CITY OF ALBUQUERQUE

May 3, 2013

Re: Casa de Oro Townhomes Grading and Drainage Plan, 921 & 923 Montano

Engineer's Stamp Date 04-19-2013 (F-14/D068)

ENGINEER'S SEAL	Casas de Oro Townhomes 921 & 923 Montano Rd.	DRAWN BY WCW/J
		GRADING AND DRAINAGE PLAN	DATE 4-19-13
		 <i>Rio Grande</i> Engineering 1606 CENTRAL AVENUE SUITE 201 ALBUQUERQUE, NM 87106 (505) 872-0989	21319-LAYOUT-4-16-13
DAVID SOULE P.E. #14522			SHEET # —
			JOB # 21319

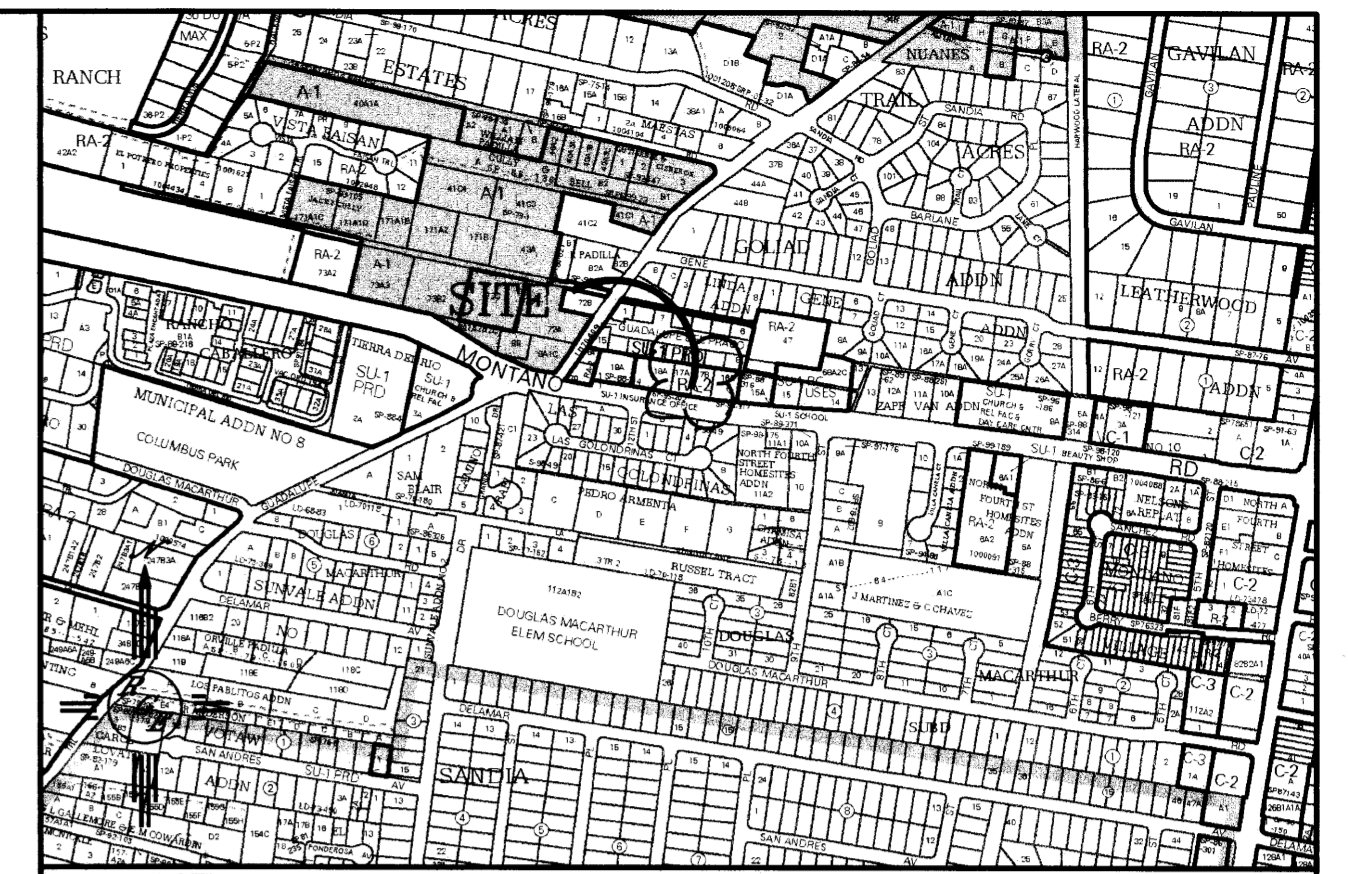
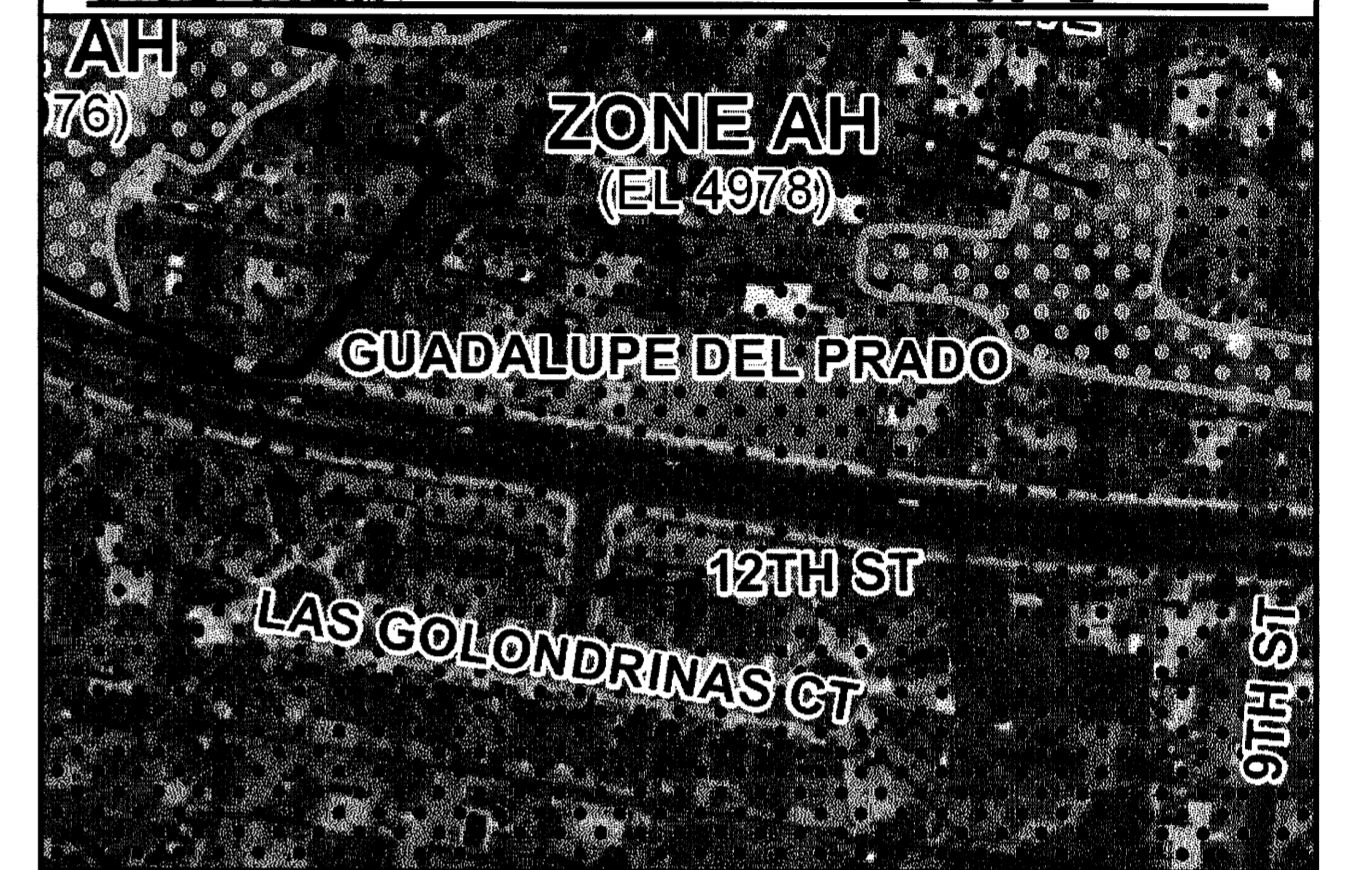
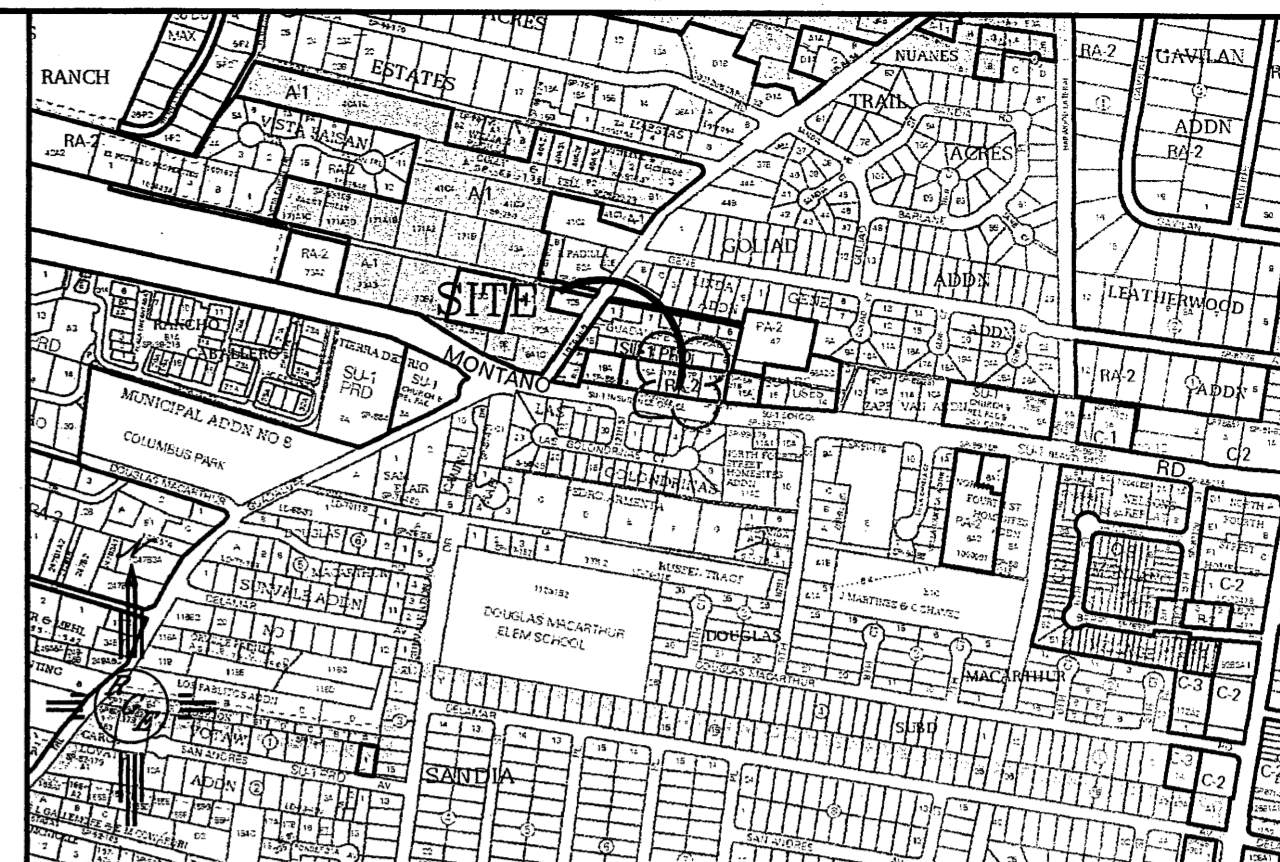
- Please provide back-of-sidewalk elevations on the grading plan.
- It appears that flows from the centrally located retention ponds might back up against the adjacent lot to the north.
- The plan shows two finished floor elevations for each of the building pads; please correct to show one finished floor and one finished pad.
